CITY OF ALBUQUERQUE

RE: **Duplex Dwelling Units – 172 Monte Largo Drive NE**
Grading and Drainage Plan for Building Permit

L23-D008
PE Stamp: 10/01/2013

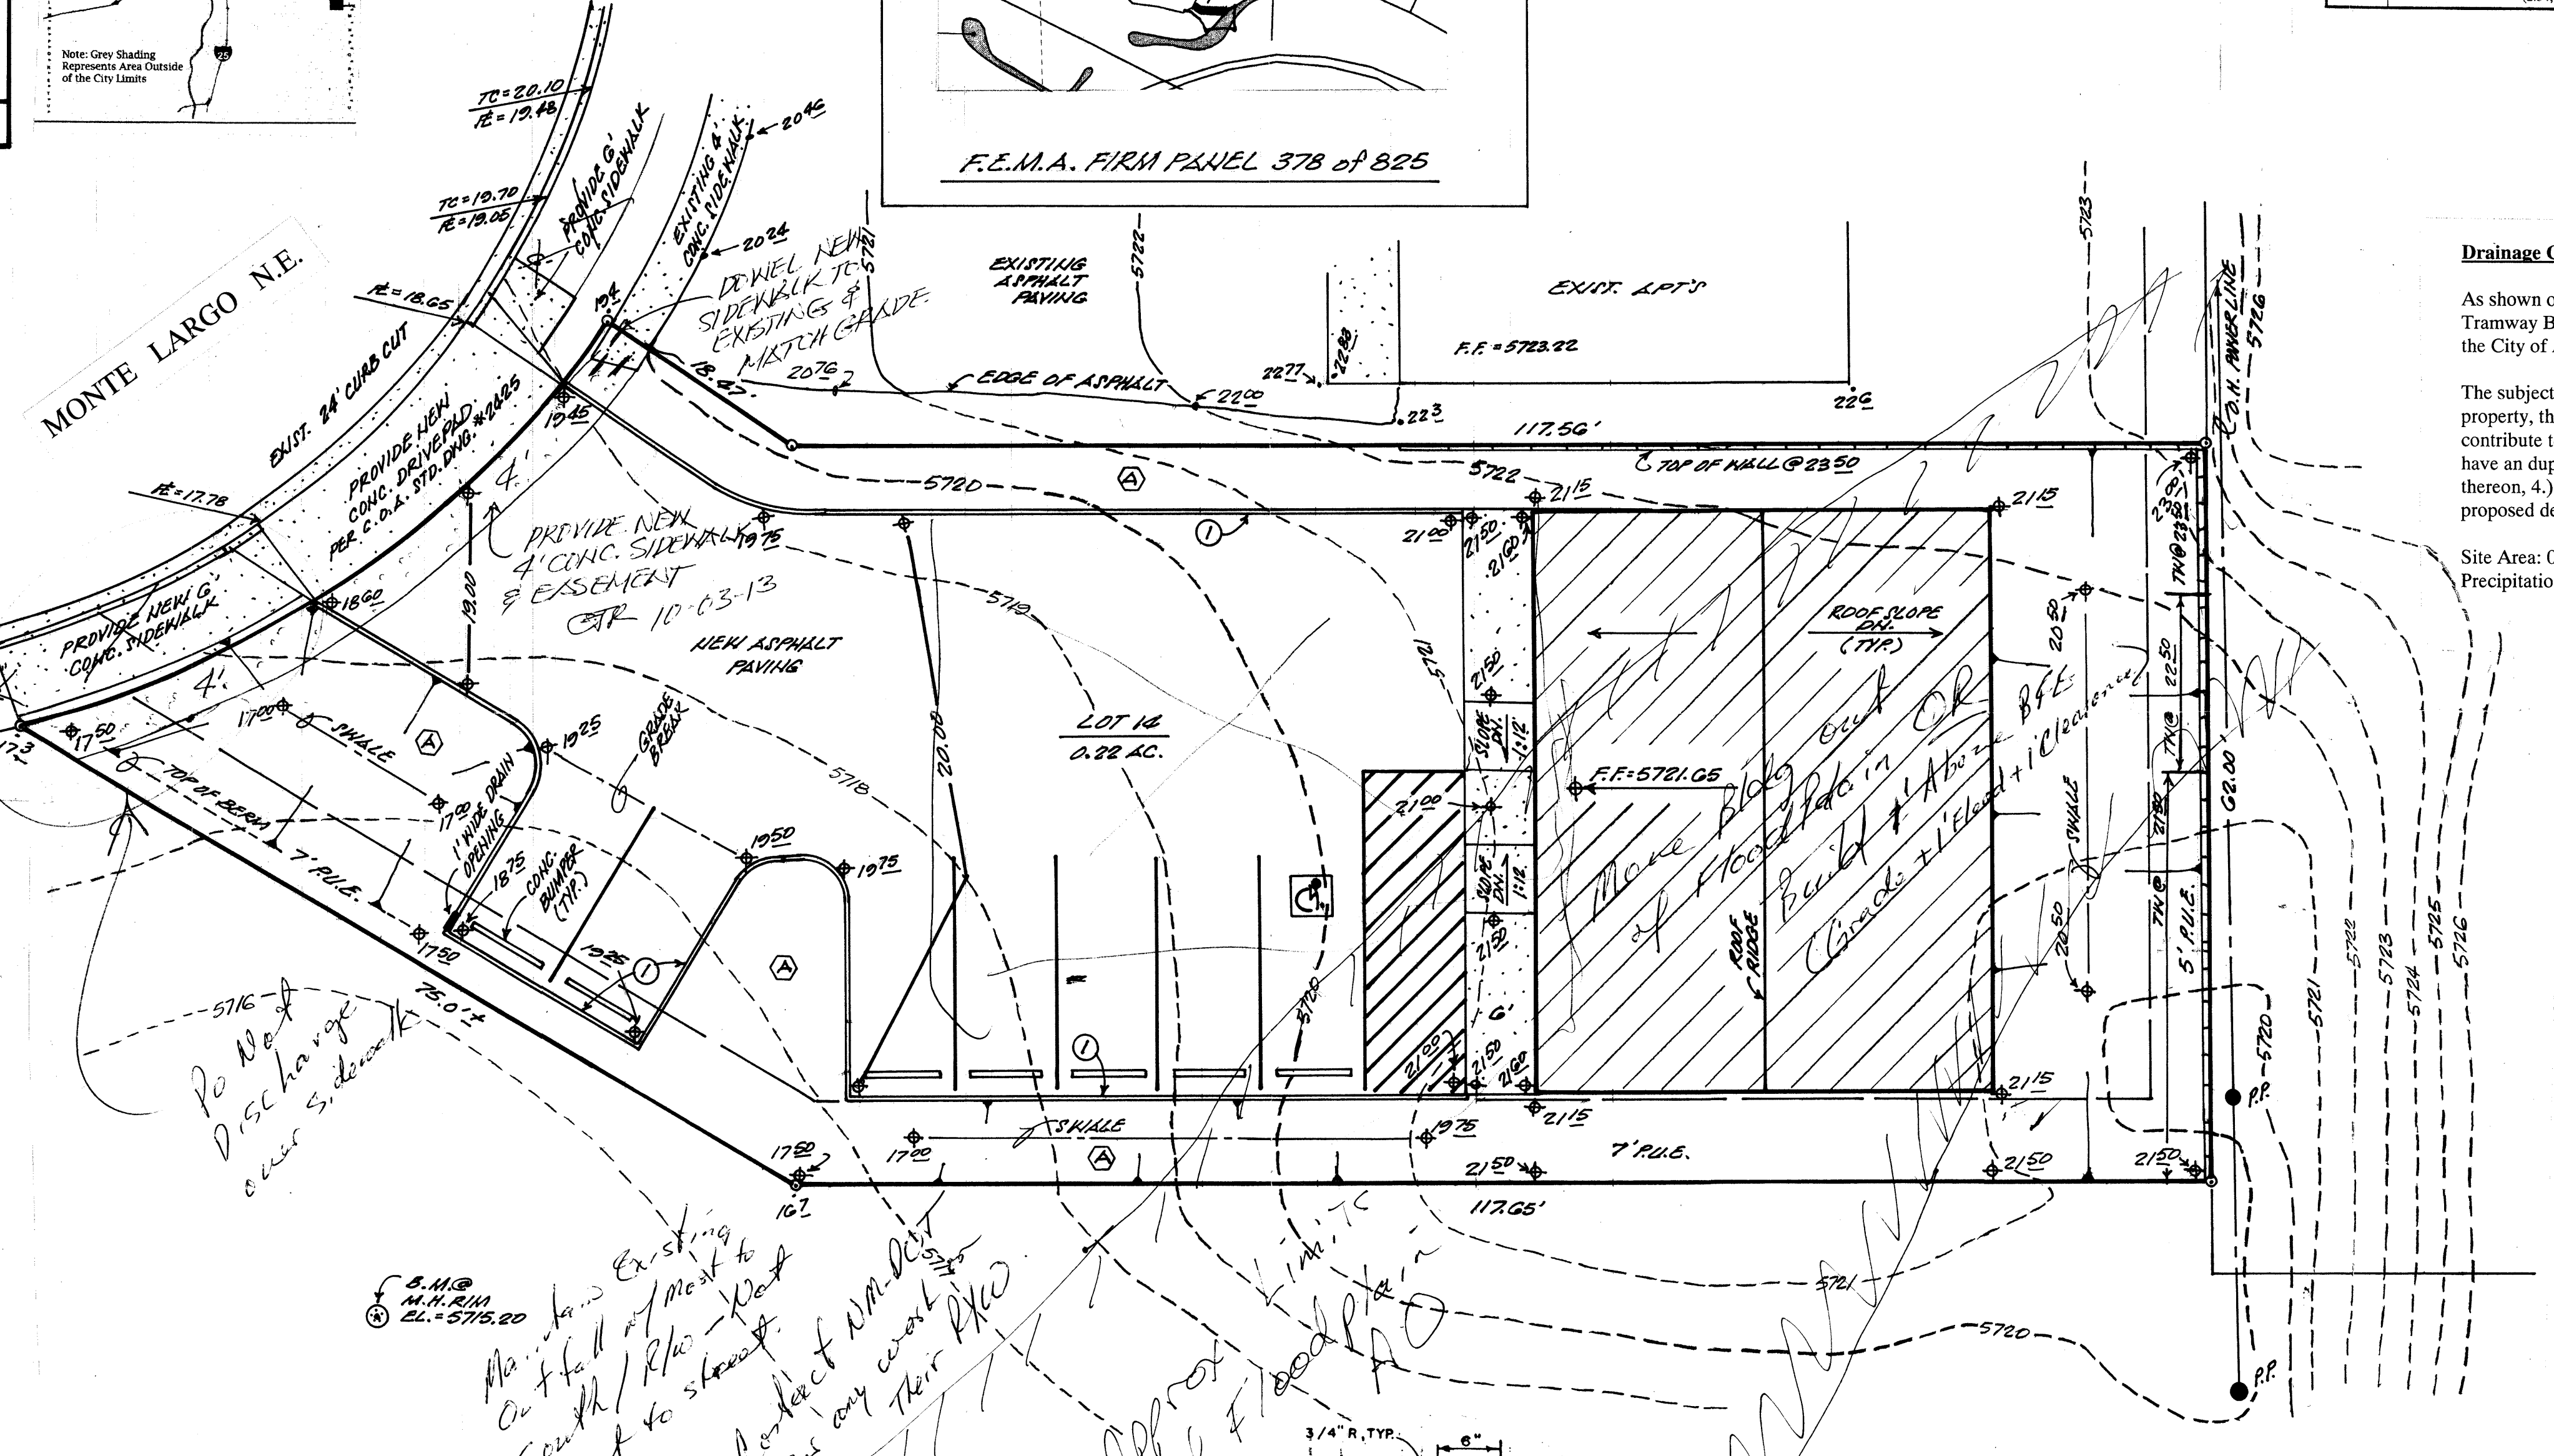
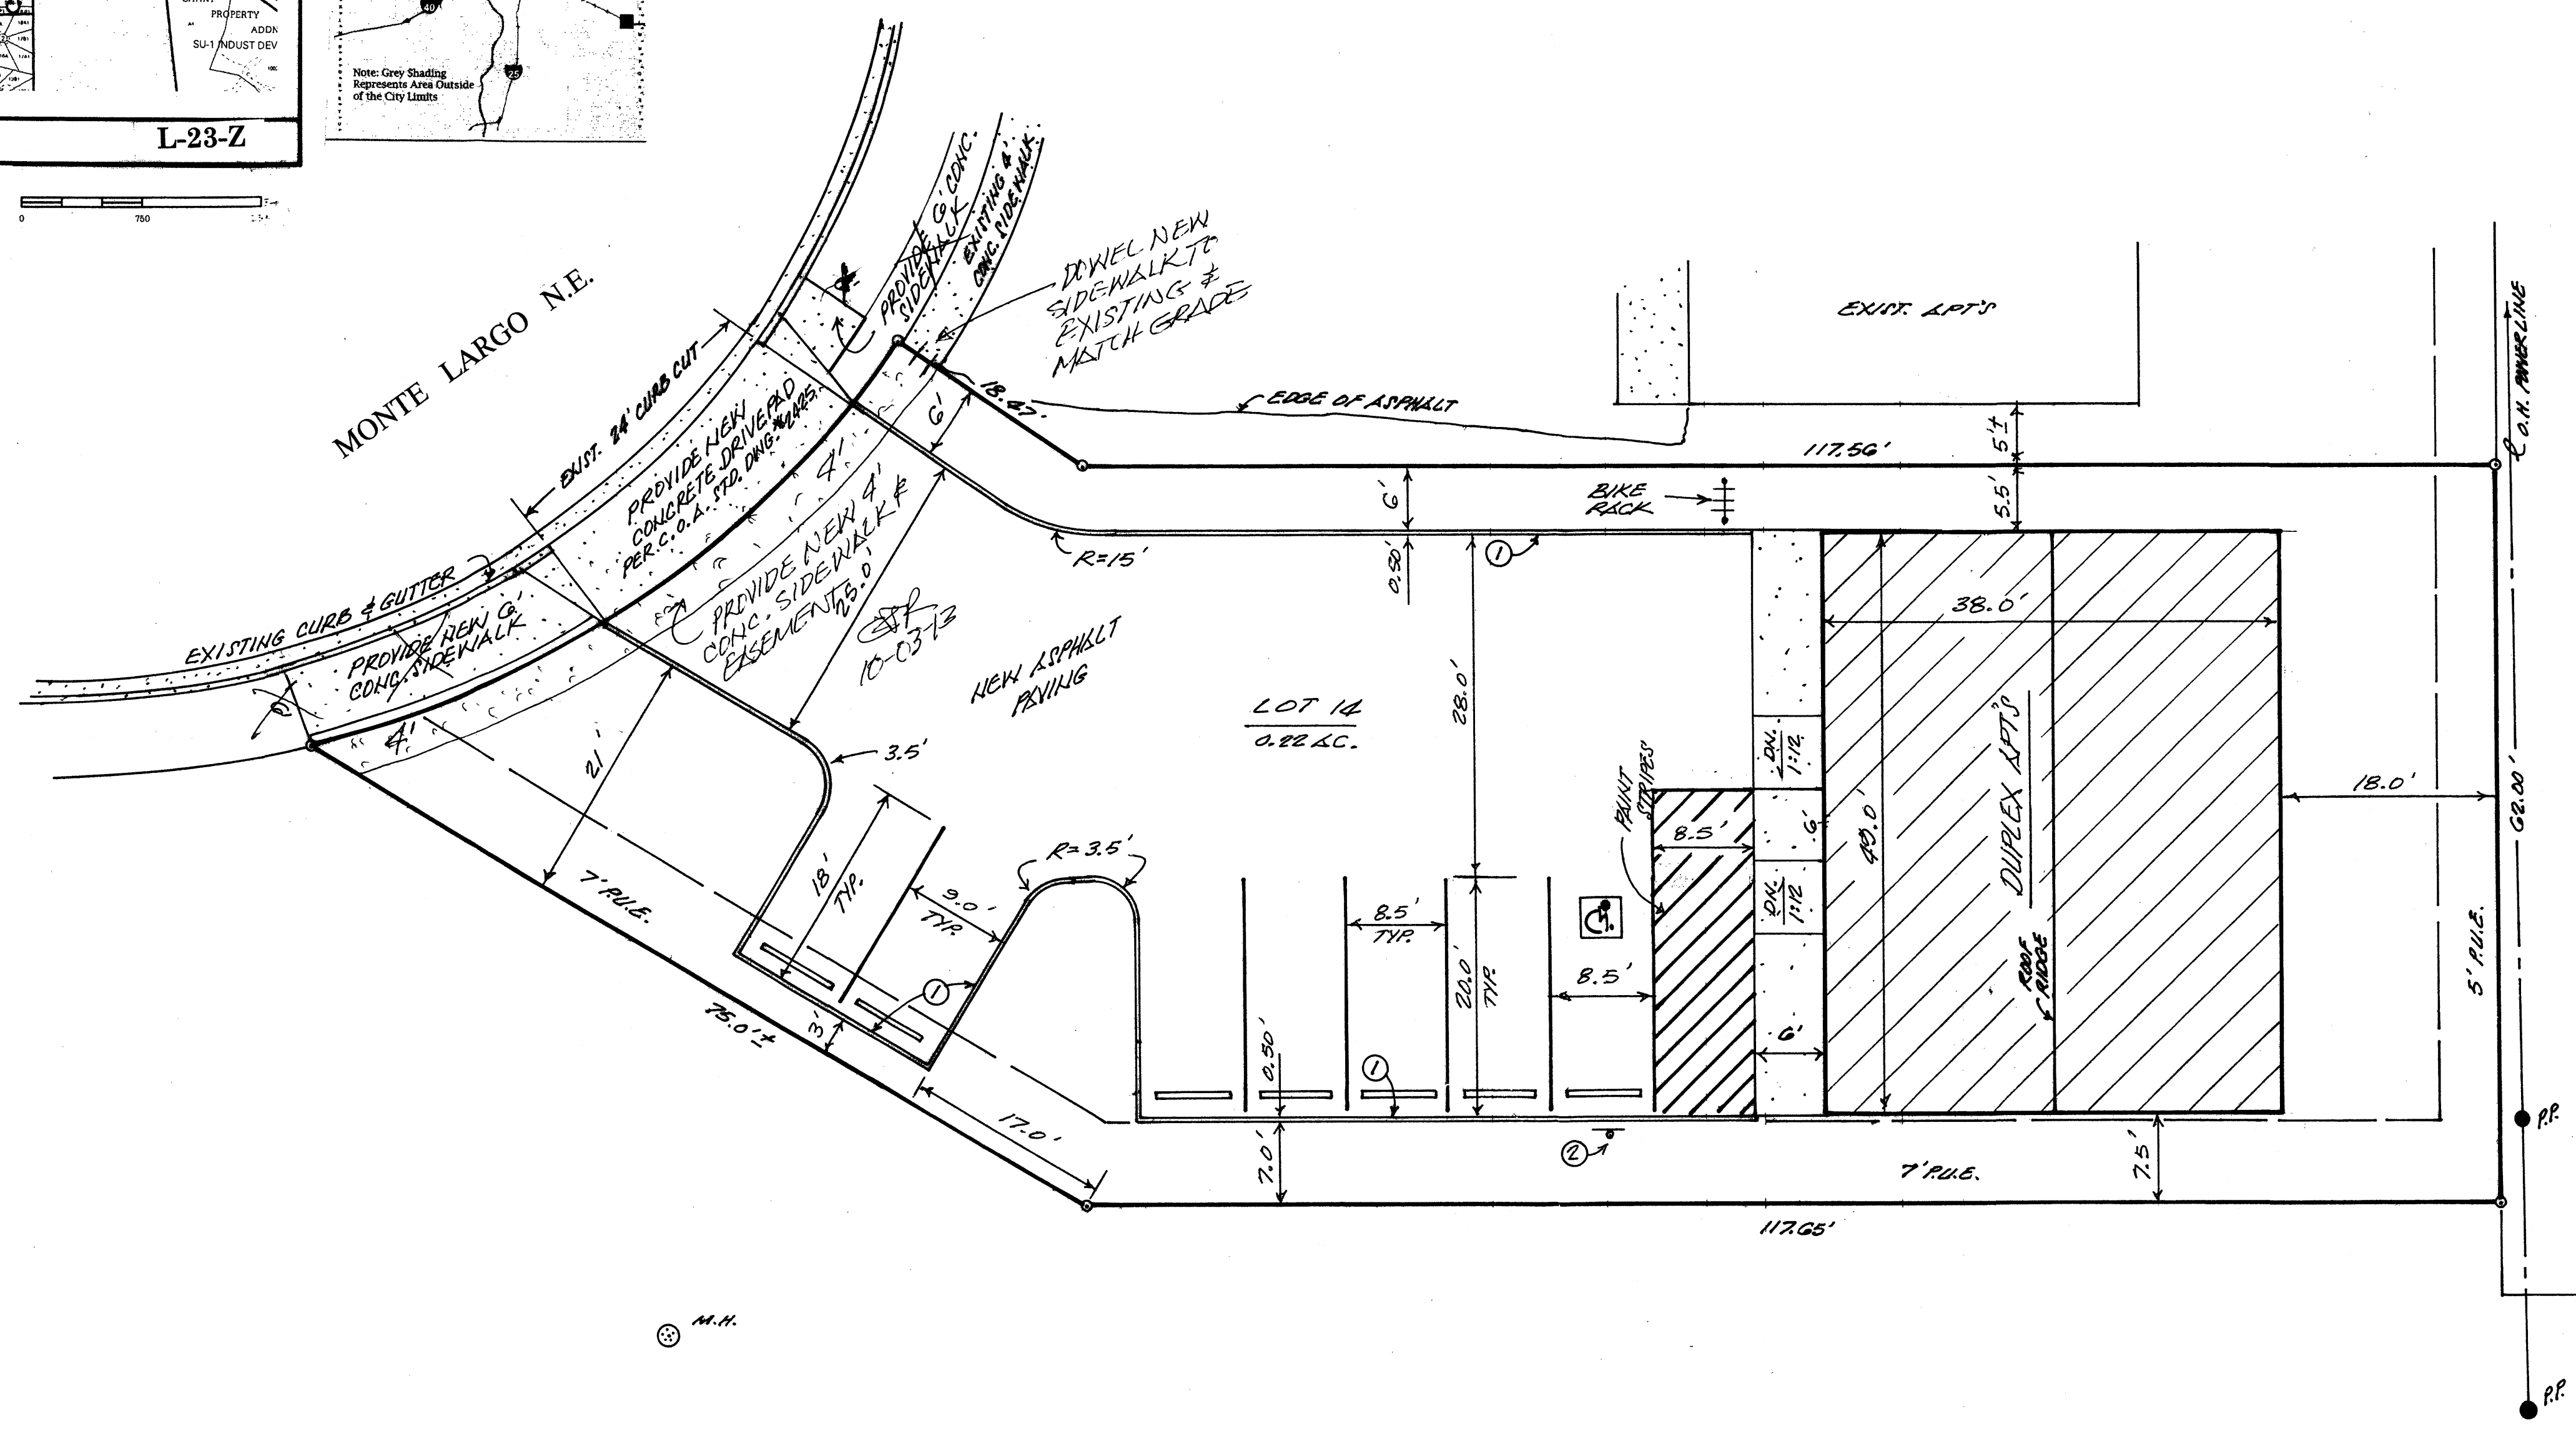
1. This site is within a Floodplain, Zone AO. Any structure within the Floodplain must have a FF grade one-foot above the Base Flood Elevation (BFE), which in Zone AO Floodplains is 1' above the existing grade.

2. It is our understanding that you will work with the owner to revise the Site plan to remove the structure(s) from the floodplain. As such, the following comments are only general in nature to guide your resubmittal.

3. The majority of the existing site runoff flows to the south, and is intercepted by an existing drainage channel on the NM-DOT Right-of-Way (R/W) for I-40. The proposed plan to divert most of the flow out the driveway, and west along Monte Largo is not acceptable. Maintain the existing flow pattern, and provide appropriate erosion and sediment control to prevent damage to the adjacent R/W.

4. Clarify toe of slope on the adjacent NM-DOT R/W, where site grades differ from existing grades along the Property line.
5. If the grades do not match at the property line, and any construction or grading is required on the NM-DOT R/W, it will require grading approval and a permit from the NM-DOT, District 3. Prior to City approval of this plan, we require documentation (or an email) from NM-DOT of their concurrence with work proposed within their R/W, and citing the PE Signature date on the plan that they approve. (Contact Timothy Trujillo, Drainage Engineer: 505-798-6690)

6. The proposed water harvesting area at the SW corner of the site should not drain over the sidewalk. Either provide stabilized overflow to the south property boundary, or overflow down the drivepad.
